Lead Member of the Examining
Authority
North Falls Offshore Windfarm DCO
National Infrastructure Planning
Template Quay House
2 The Square, Bristol
BS1 6PN

Our Ref: 20048269
PINS Ref: EN010119
Date: 25 April 2025
Telephone: 03330 322546

Planning Act 2008 – Application by North Falls Offshore Wind Farm Limited for an Order Granting Development Consent for the North Falls Offshore Windfarm (EN010119)

Indicative Planting Cross-sections at the Onshore Substation

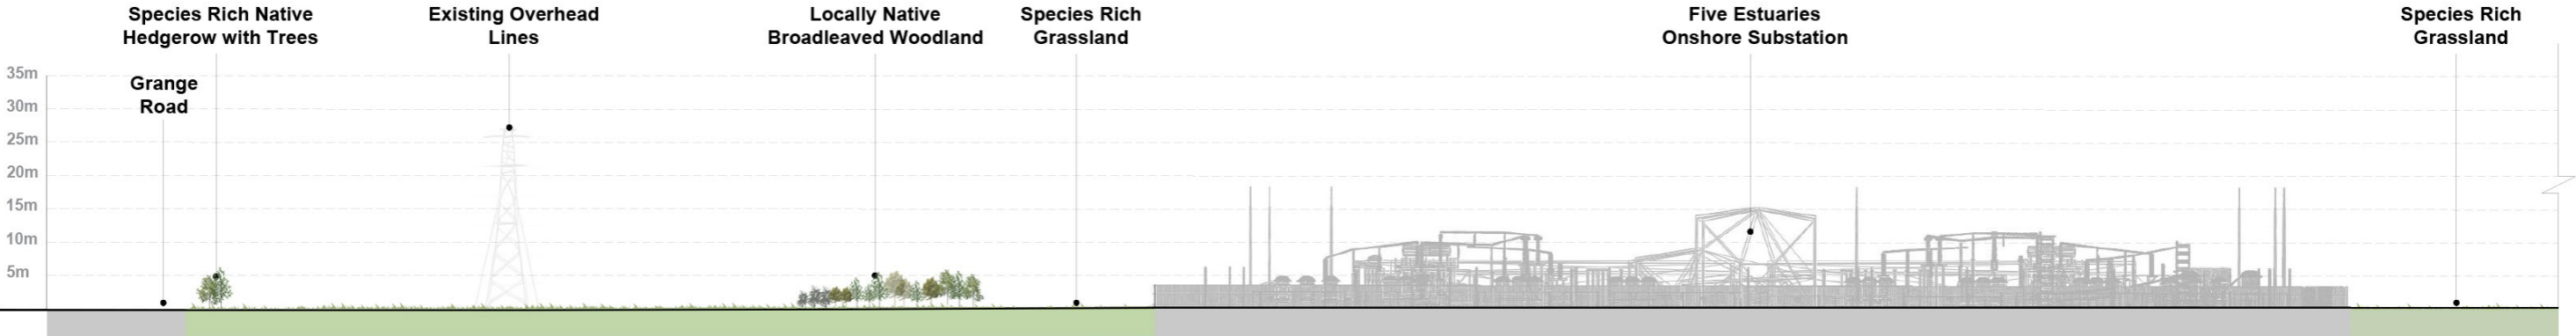
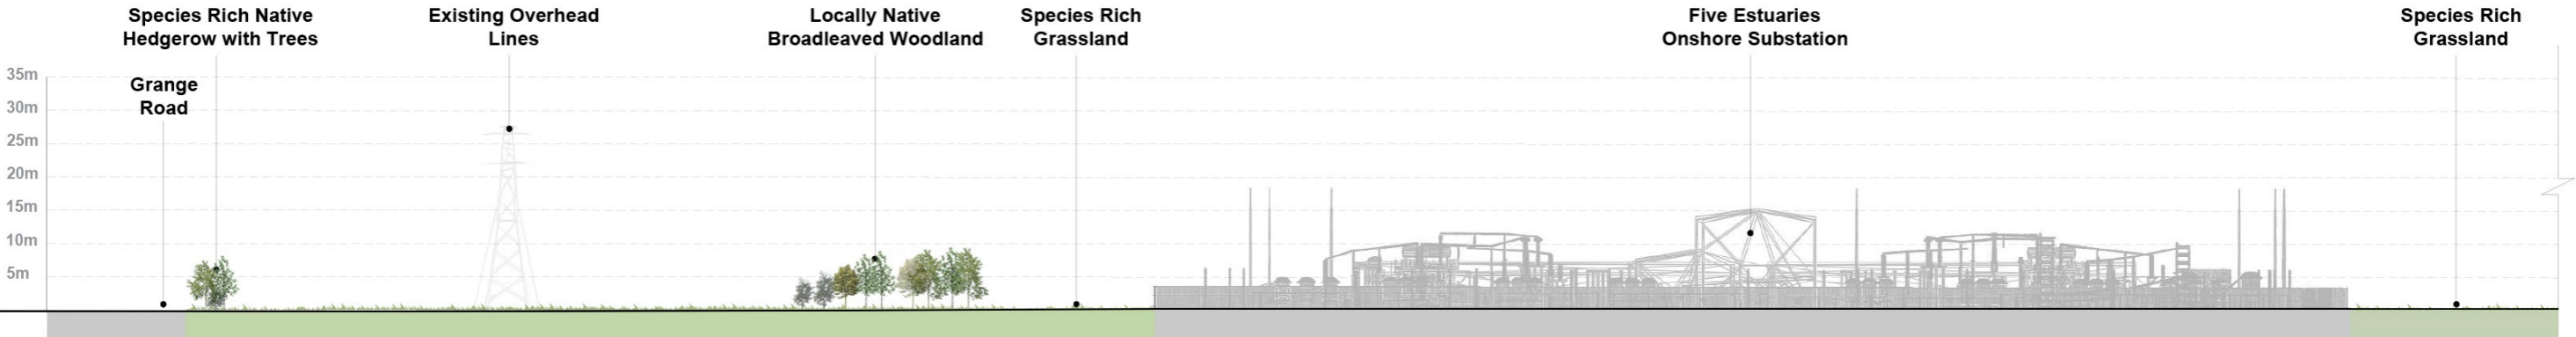
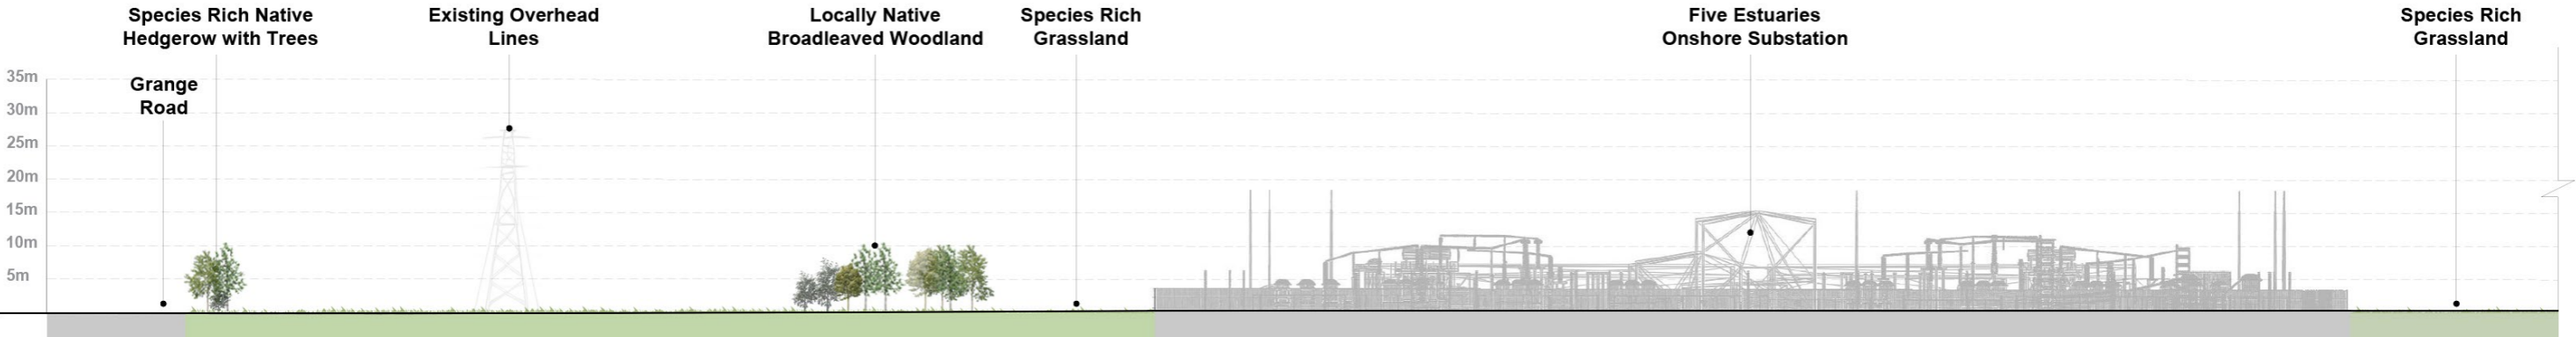
Cross-section AA' Year 1 - An indicative human receptor needs to be shown in Grange Road/Ardleigh Road. Both ends of the cross section are labelled A and Grange Road. One end needs to be A' Ardleigh Road. The height of the hedgerow with trees in Year 1 is shown as c5m, whilst the majority of the planting will be hedgerow c1m in height. This is misleading.

As shown on the cross-section, the width of the locally native broadleaved woodlands is wider than the 20m width committed to on the indicative plan. How will the applicant ensure this additional planting will be delivered?

Most of the sub-station structure will be visible in Year 1.

Cross-section AA' Year 15 - The height of the hedgerow with trees in Year 15 is shown as c10m, whilst the majority of the planting will be hedgerow likely managed at c2-3m max. The tallest elements of the sub-station structure will still be visible.

LUC		www.landuse.co.uk	
Project North Falls Onshore Substation			
Client North Falls			
LUC Job No 12155		Scale @A1 1:500	Status S0
Drawing Title Landscape Sections Sheet 2 of 6			
Drawing No 12155-LUC-00-VS-L-0002		Rev A

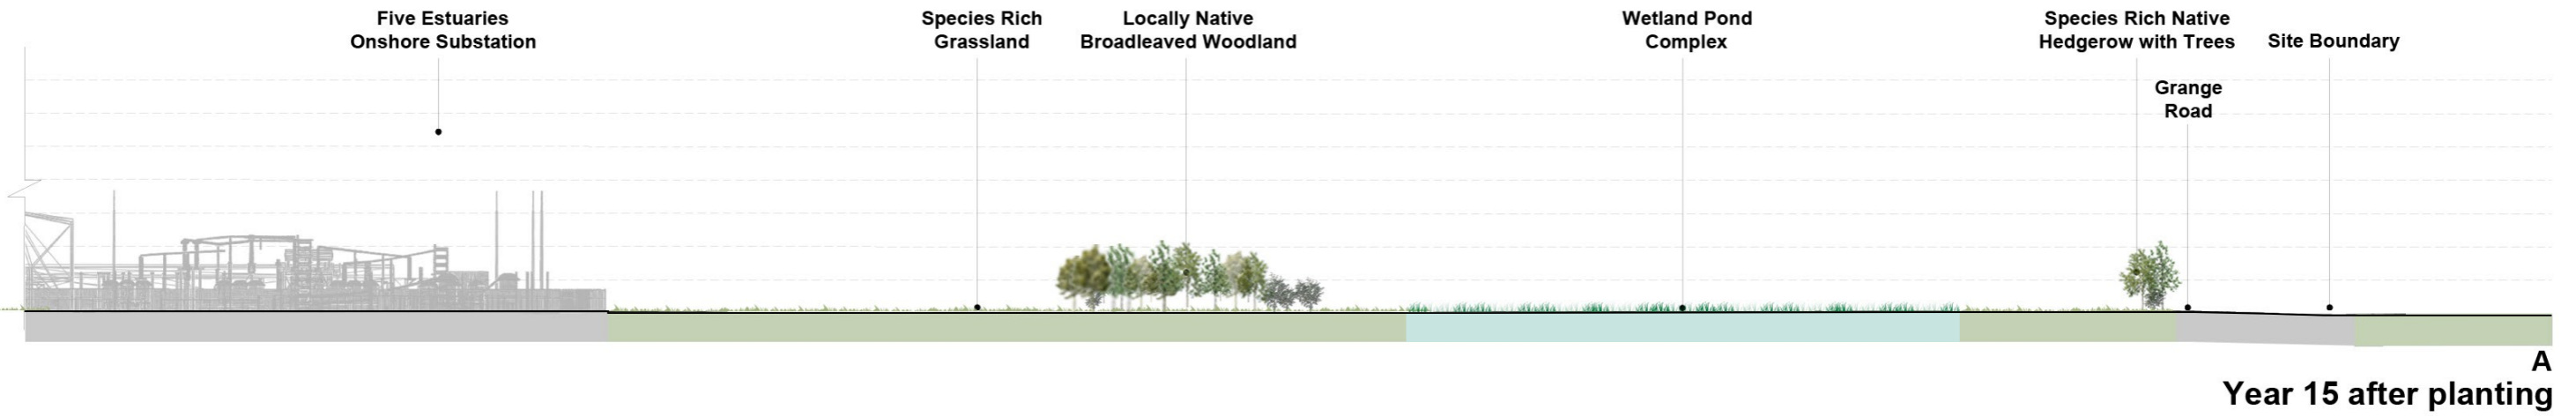
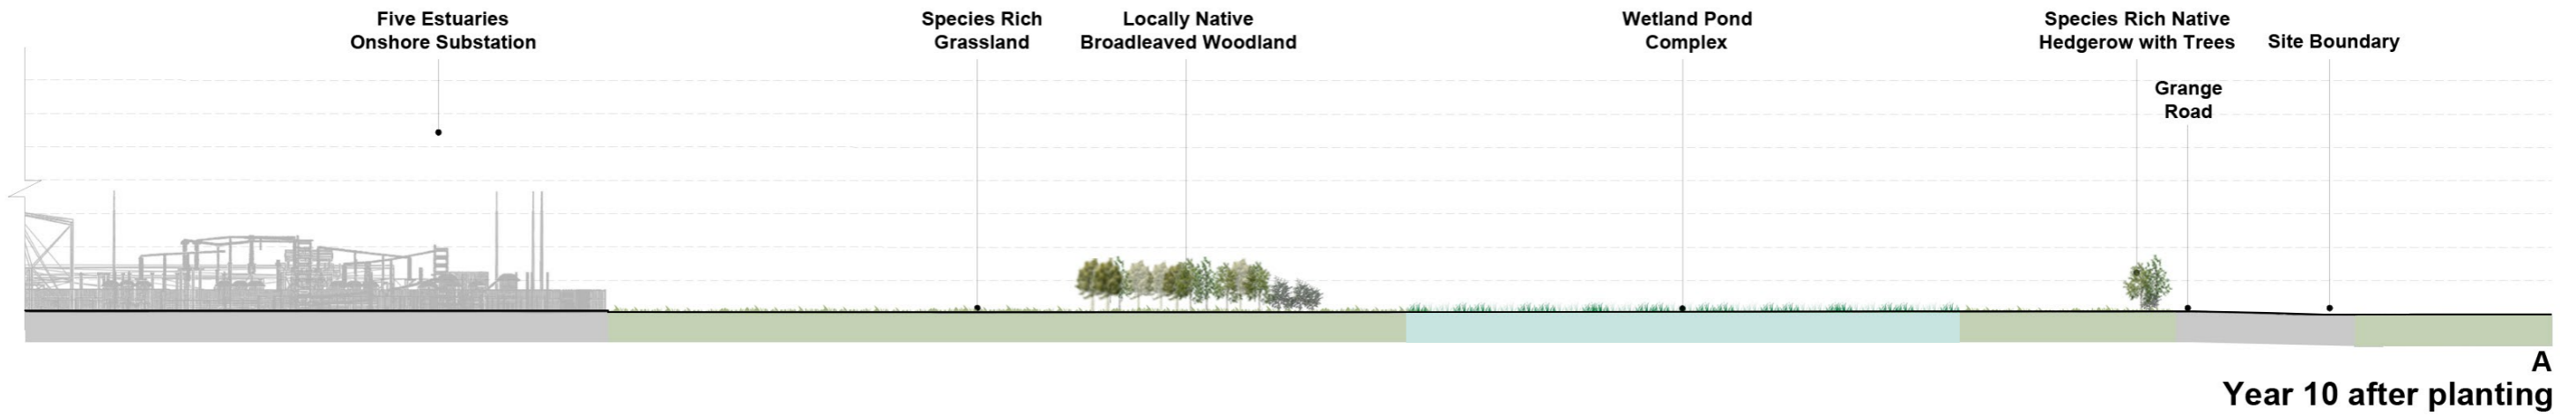
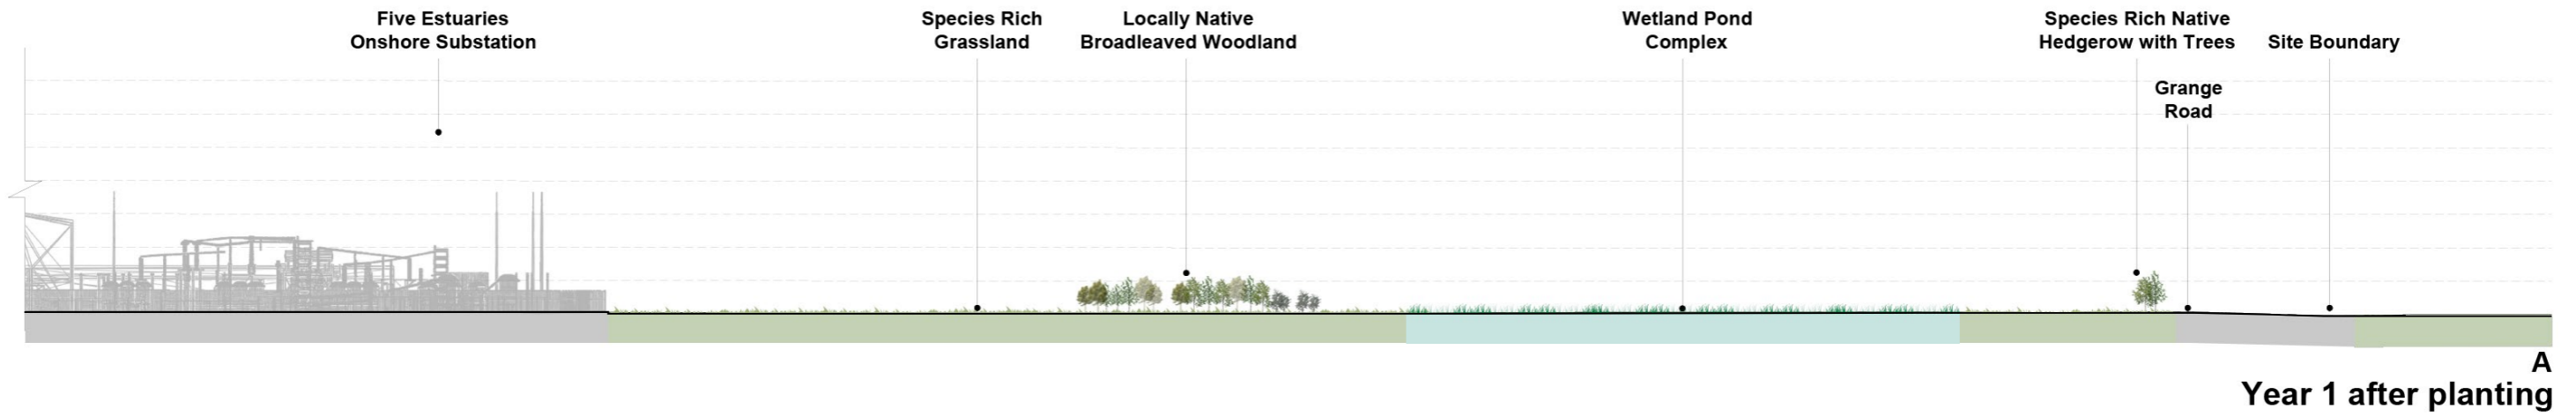
Cross-section CC' Year 1 - C' lies on the PRow along the northern boundary and should be labelled as such. An indicative human receptor needs to be shown in Grange Road/Ardleigh Road and the PRow.

Same issue with indicative height of hedgerow with trees being overstated and width of locally native broadleaved woodlands.

Cross-section CC' Year 15 - Same issue likely with visibility Year 1. The height of the hedgerow with trees in Year 15 is shown as c10m, whilst the majority of the planting will be hedgerow likely managed at c2-3m max. The tallest elements of the sub-station structure will still be visible at Year 15.
